Rezoning Transportation Analysis

Petition Number: 2023-095

Date	Description
9-28-23	First Review (IW)

C200

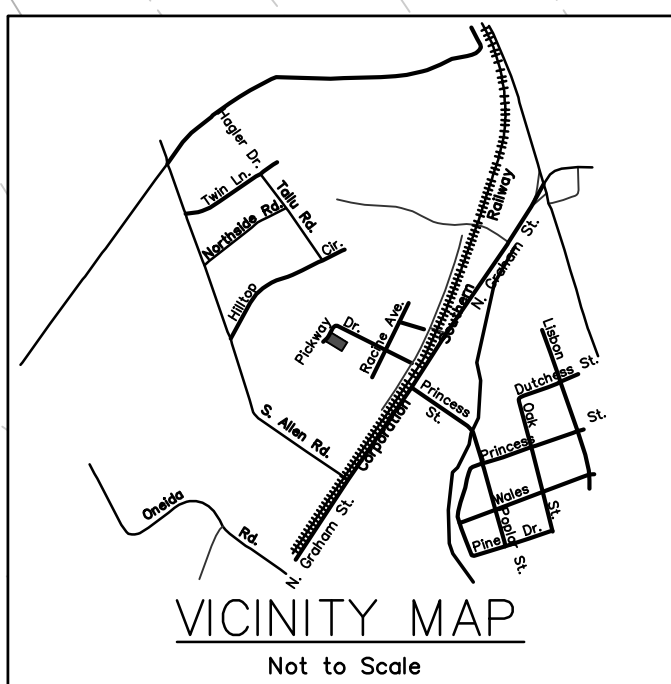
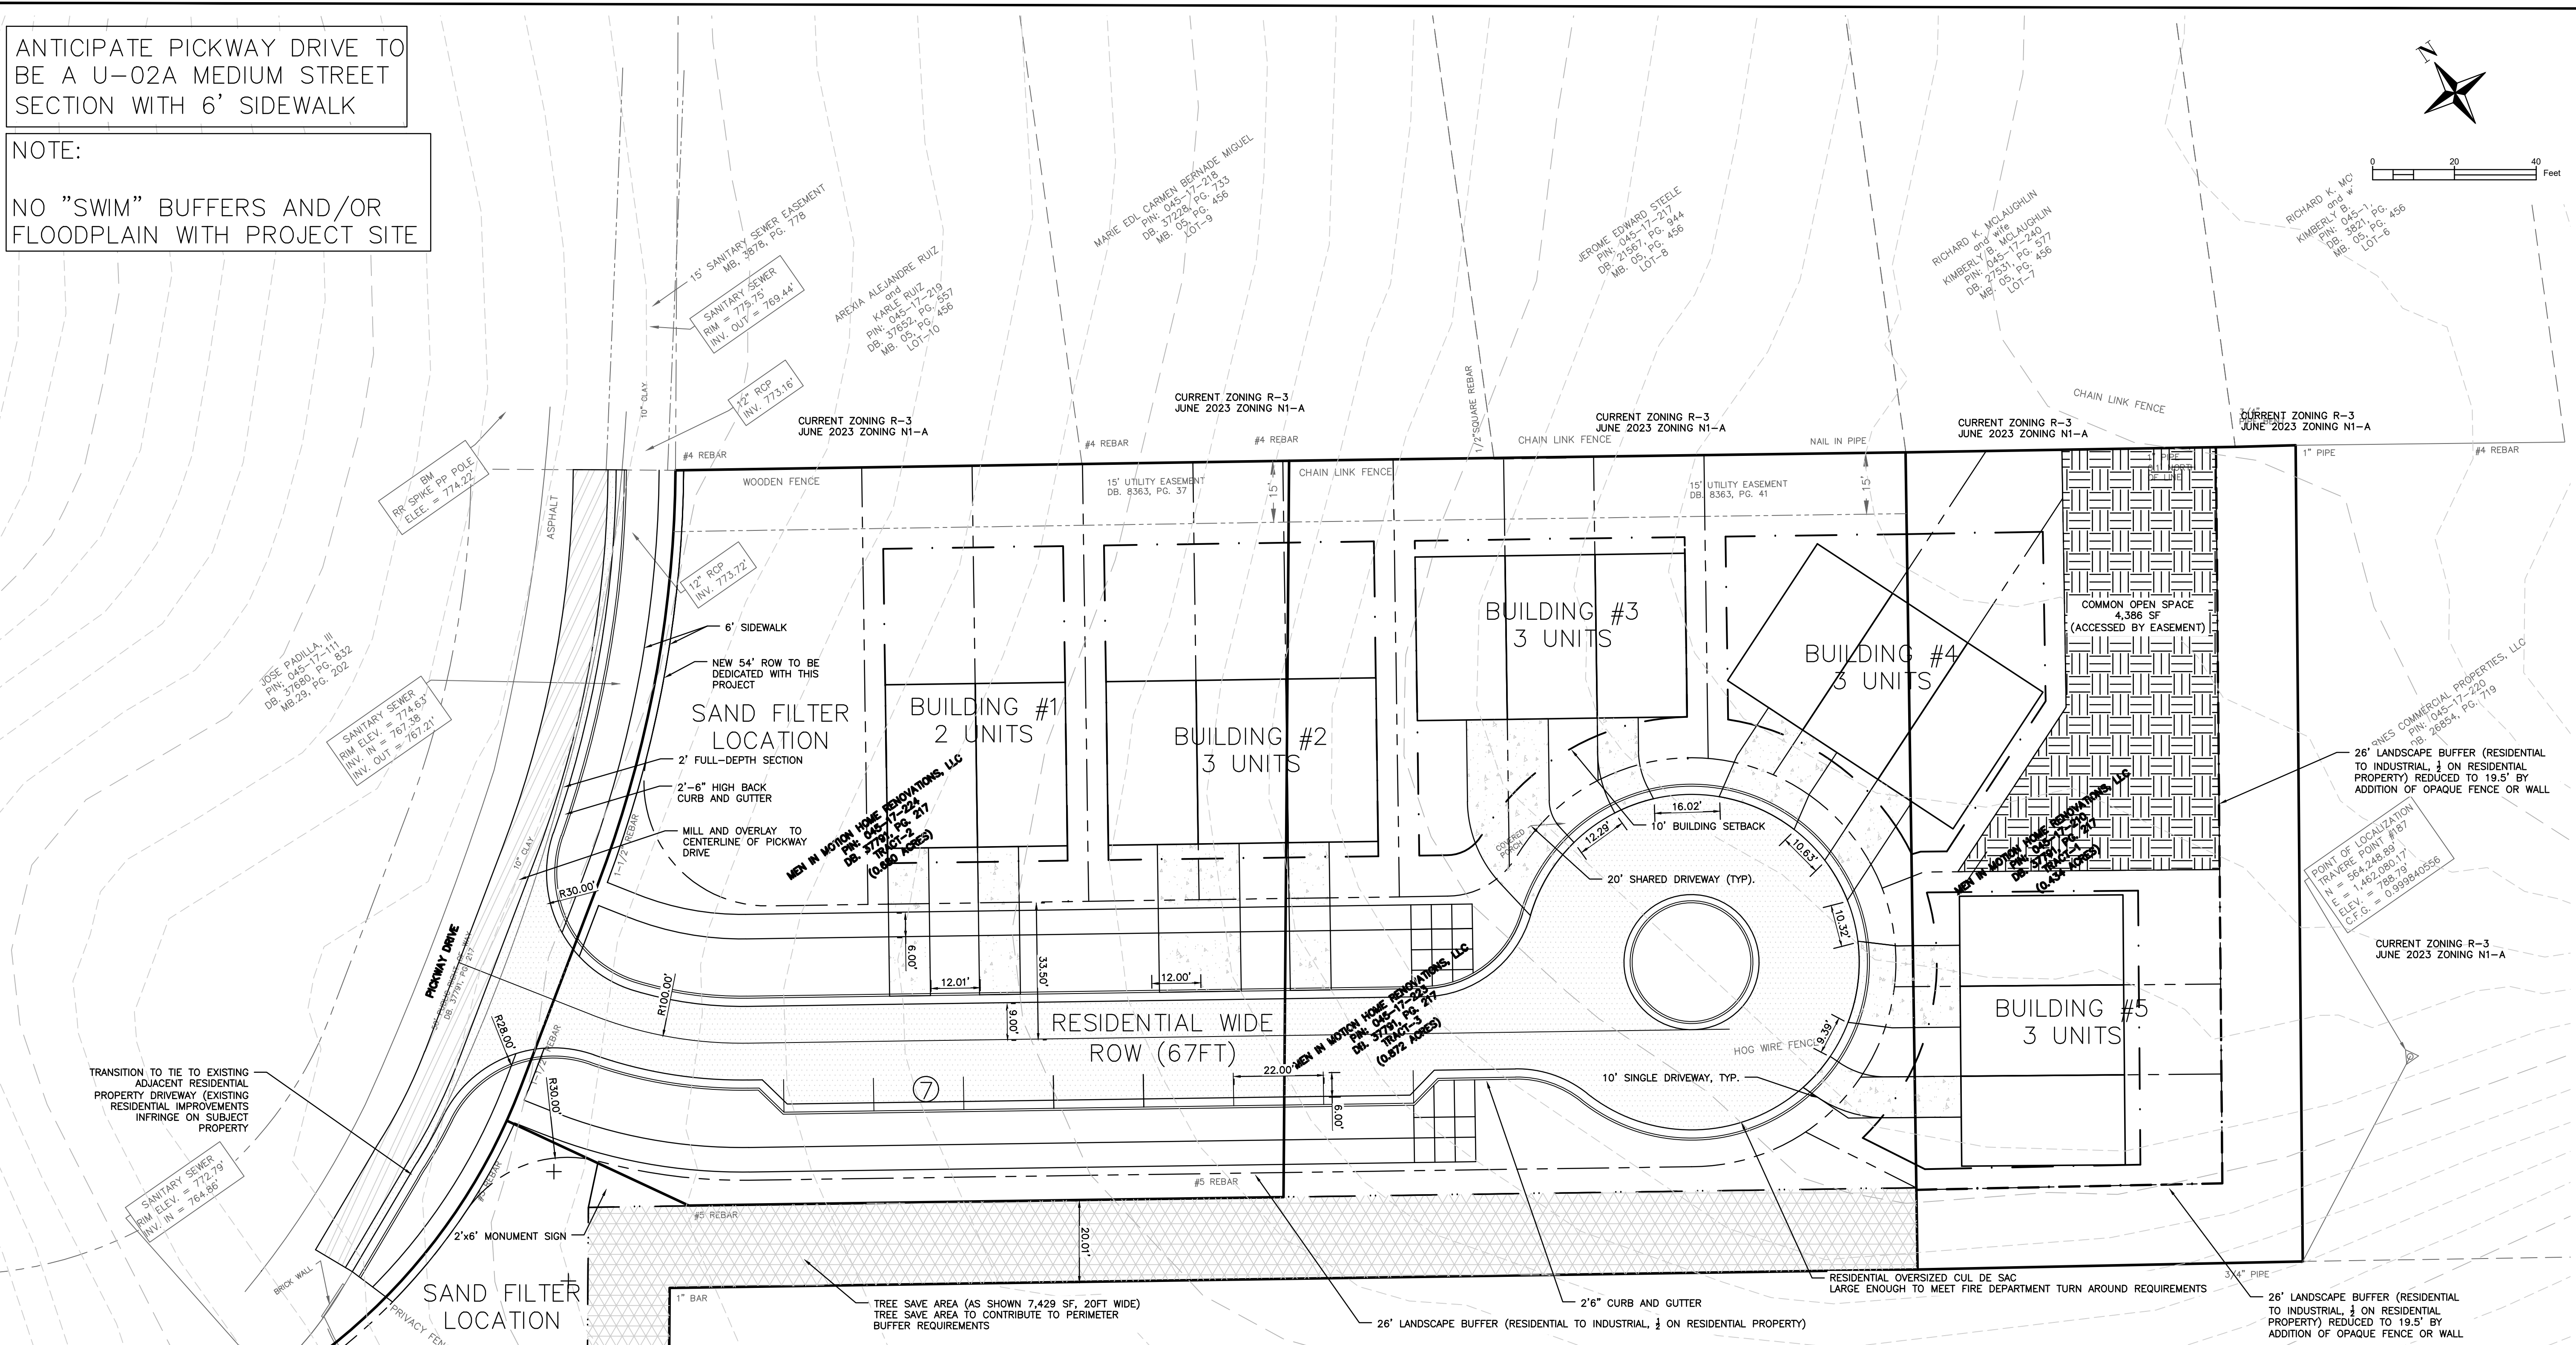
Pickway Drive: Location of future back of curb and gutter to be installed 17.5' from centerline.

CLDSM standard Local Residential Wide Street U-03A2

Label and dimension the curb and gutter from the centerline for each road on the site plan.

3. Revise site plan and conditional note(s) to commit to dedicate 31.5 feet of right-of-way from the road centerline. The site plan shall label and dimension the right-of-way from the road centerline.

5. Revise site plan and conditional note(s) to commit to an 8' planting strip and 6' sidewalk per the CLDSM U-03A2 along Pickway Drive per UDO Article 33.

6. Revise site plan and conditional note(s) to commit to providing an ADA on-street parking space to meet Federal ADA guidelines.

7. CDOT requests petitioner to revise site plan and conditional note(s) to commit to milling and overlaying the entire road instead of half, as the existing road is substandard and half milling may create grade issues at the tie-in between pavement sections.
8. Add a conditional note specifying “the Petitioner shall dedicate and convey in fee simple all rights-of-way to the City before the site’s first building certificate of occupancy is issued. CDOT requests rights-of-way set at 2’ behind back of sidewalk where feasible.”
9. Add a conditional note specifying “All transportation improvements will be approved and constructed before the site’s first building certificate of occupancy is issued.”
